From: Martyn White
Sent: 26 October 2018 16:10
To: Planning.Responses
Subject: CM/24/18/PL

CM/24/18/PL

WEST ELEVATION

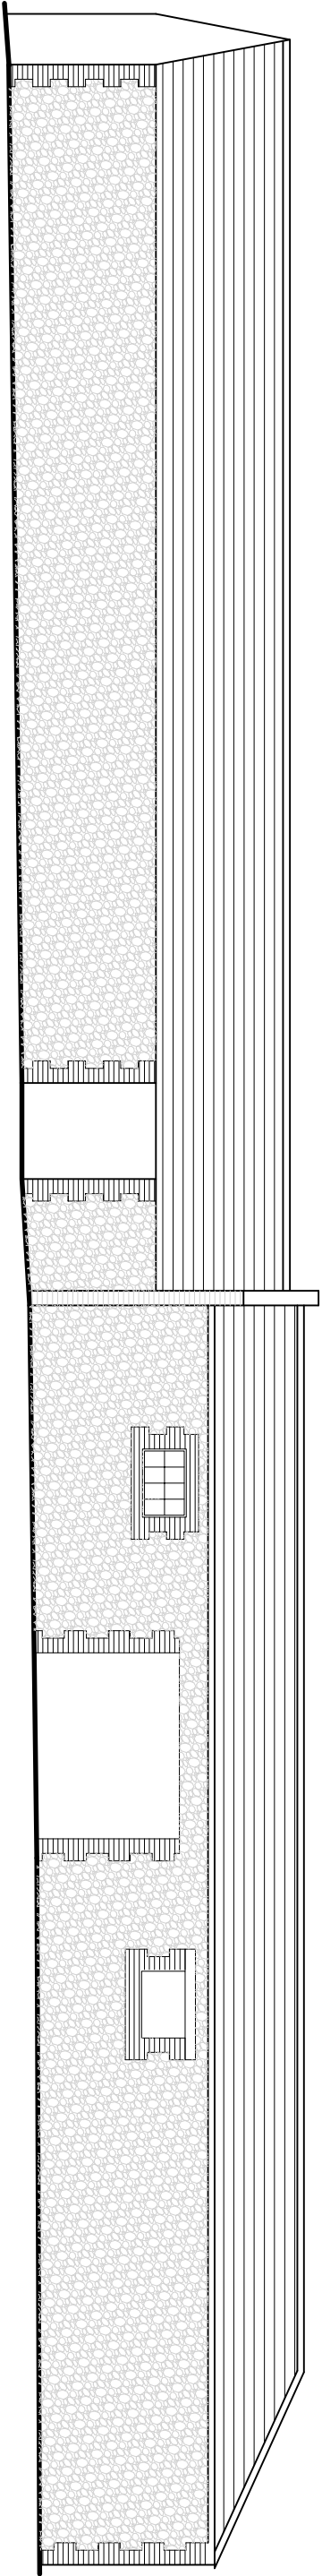
The two new French windows could potentially have a significant impact upon the western elevation of the building, and their design will be central to their impact. This will require further consideration.

It is therefore suggested that the glazing should be set deep in the reveal of existing openings in order to create shadow lines, whilst and minimising reflections and impact. This is especially true of the large French windows which are proposed on the western elevation.
